From: Bryan McSwain
Sent: Monday, August 17, 2015 8:49 AM
To: angie@cavinessandcates.com
Cc: Susan G. Stewart; Oliver Tolksdorf
Subject: Tingen Pointe lots 152, 153

Bryan McSwain R.E.H.S.
Onsite Wastewater Program Specialist
Harnett County Department of Public Health
307 W. Cornelius Harnett Blvd.
Lillington, N.C. 27546
(910) 893-7547

- PLOT PLAN FOR -
CATES BUILDING, INC.
 - SUBDIVISION -
TINGEN POINTE - PHASE 6

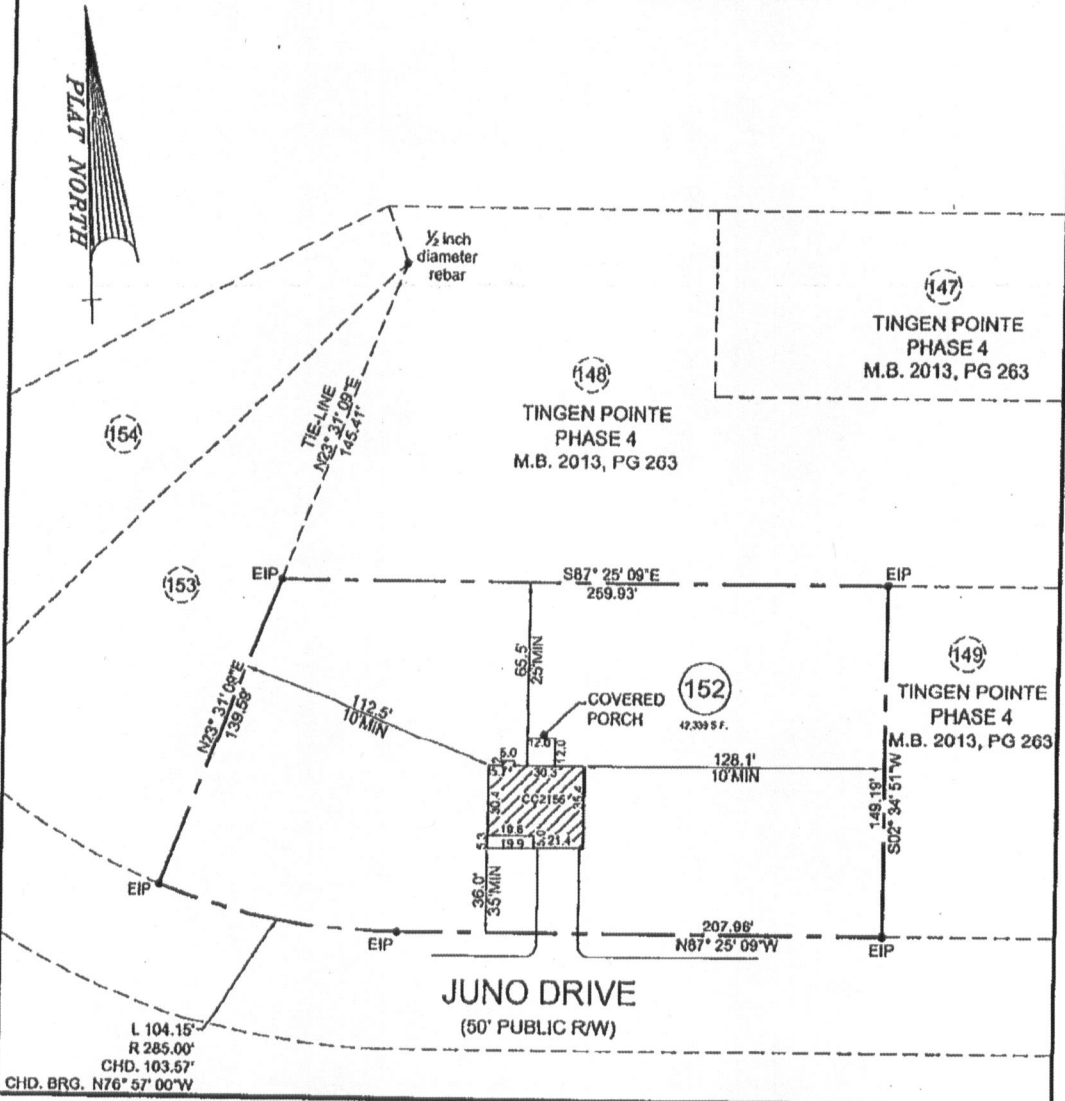
Lot 152 can be cleared removing the trees only from the house site to the left hand property line.

Once 152 is cleared let me know and I will go and layout the septic system.

Lot 153 I think the house needs to be pushed back as far as possible so the septic system can go in the front.

If you would like to keep the house as it is on the site plan, get a soils consultant to propose a septic system with repair area and submit that to me.

Once lot 153 has be cleared removing tress only let me know and I will go back and flag the septic system.
